DRB Application No.: 04DRB-00478 (SBP)
Project Name: CLIFFORD INDUSTRIAL PARK
Agent: Ken Hovey

CITY OF ALBUQUERQUE
PLANNING DEPARTMENT
Development Review Board

RE: Tract 49, Clifford Industrial Park/SPBP

A.2

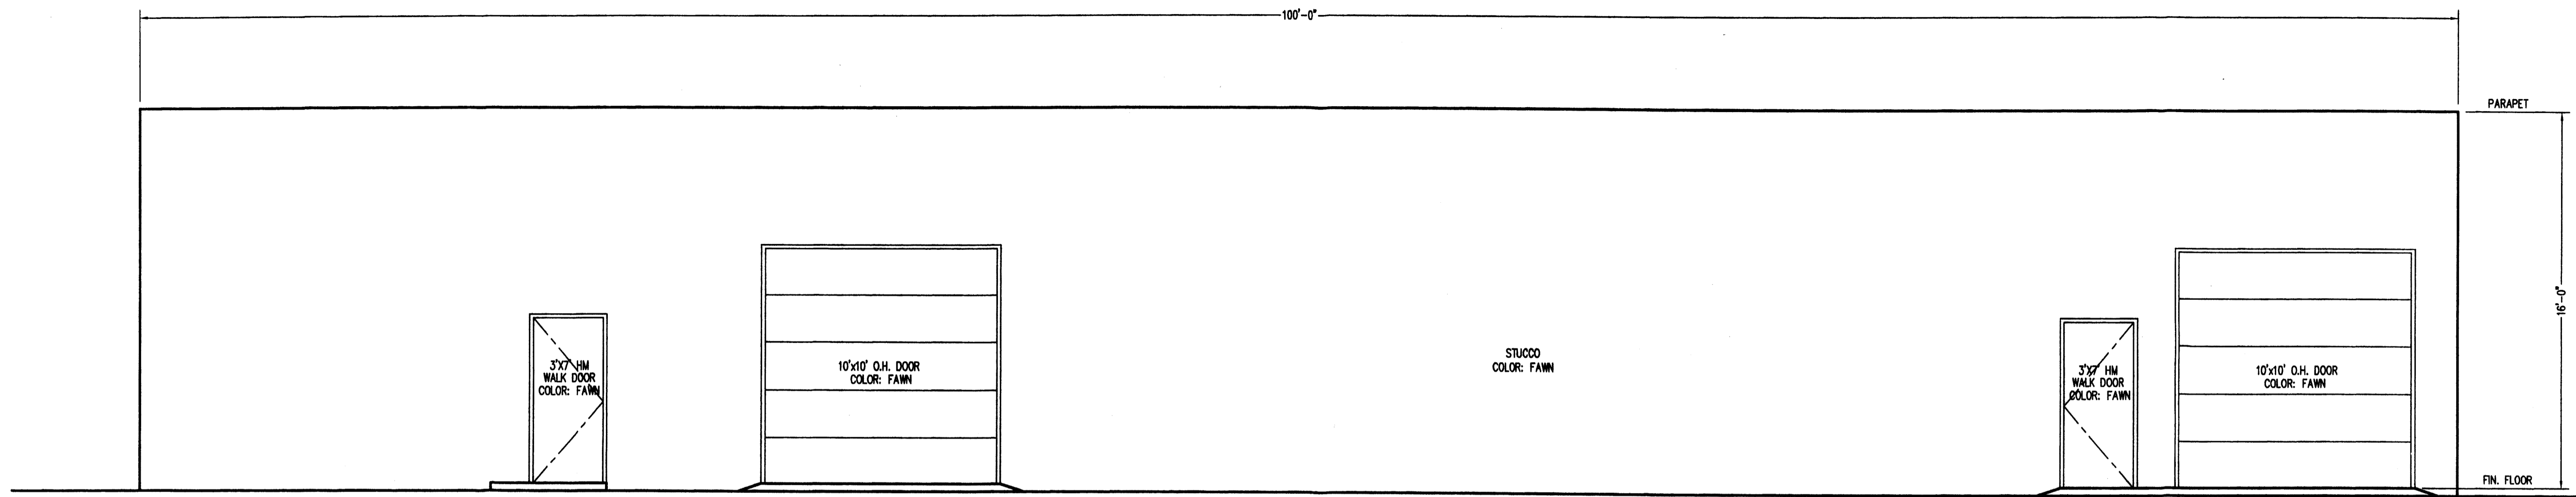
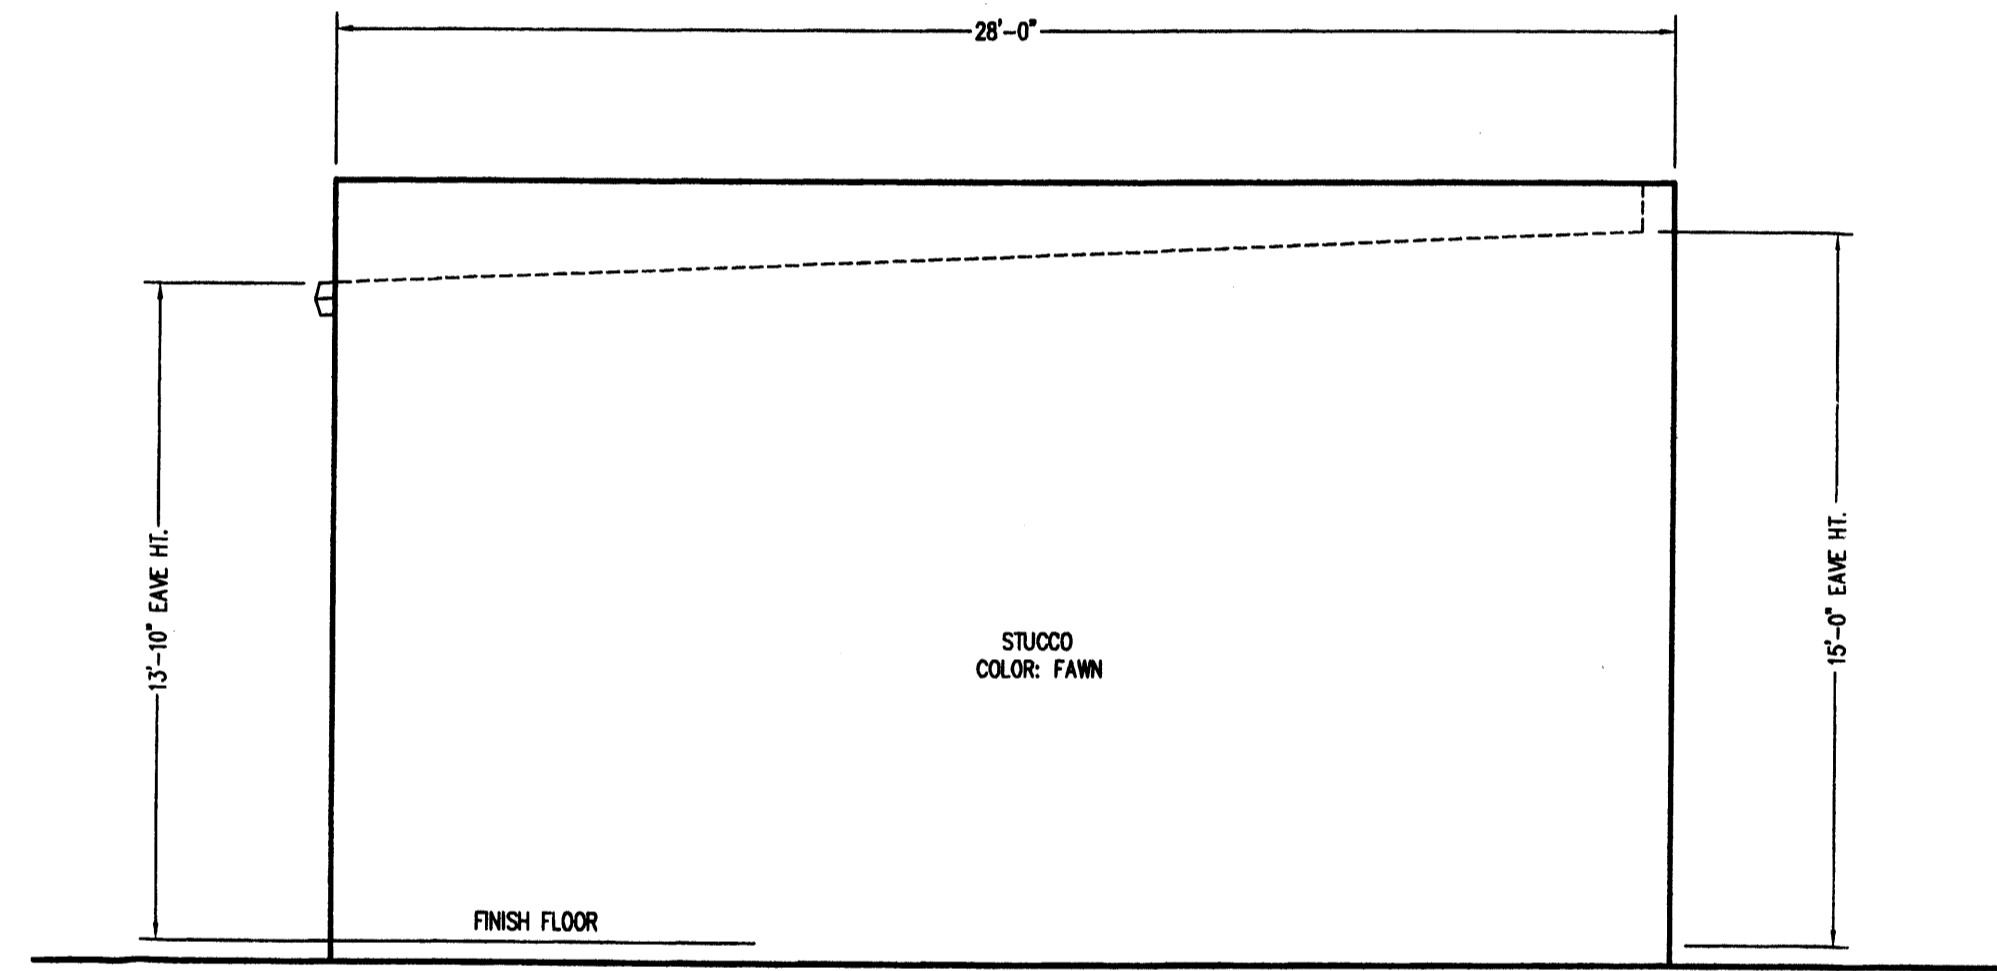
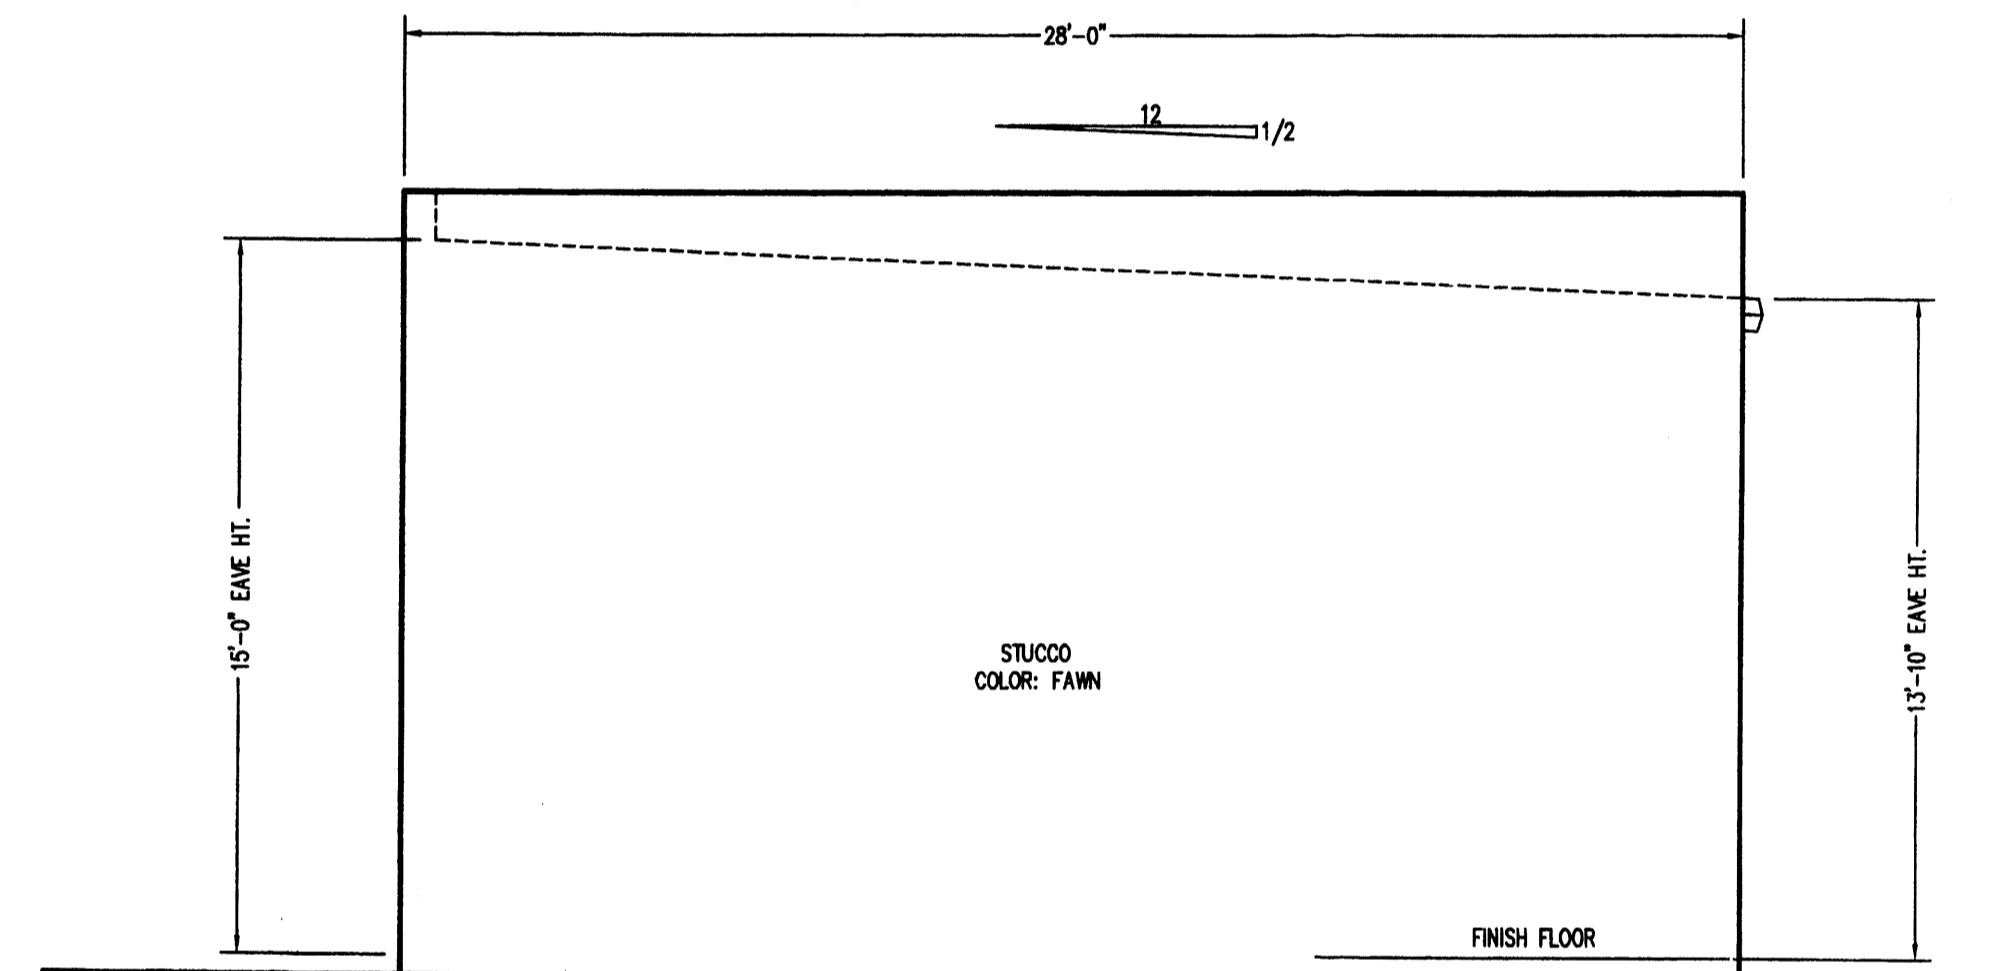
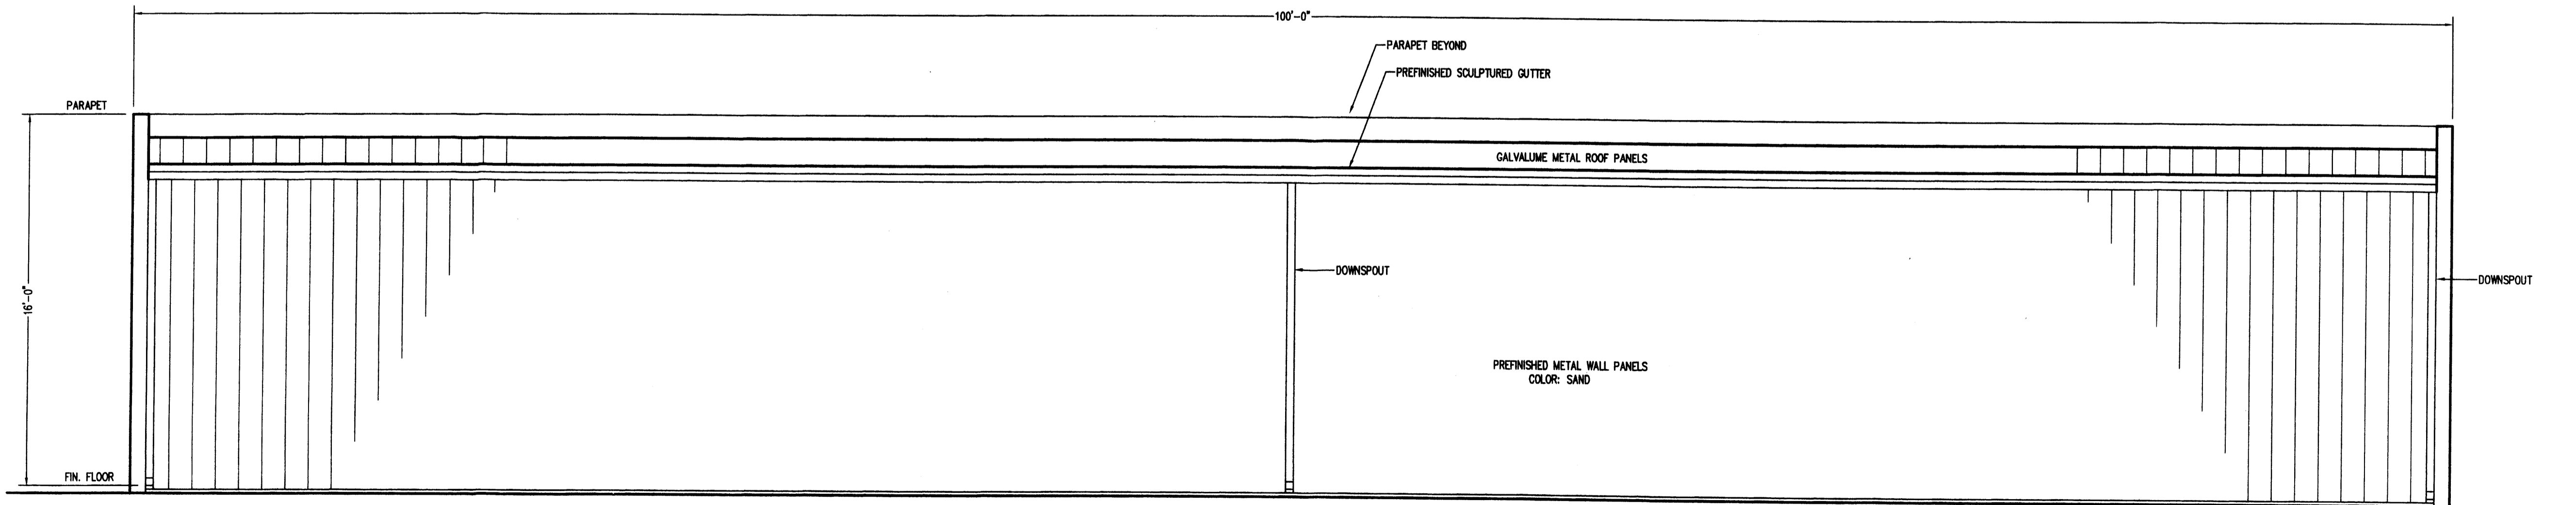
11. Elevations of building: Overall width missing as is the color of the doors. **DONE**
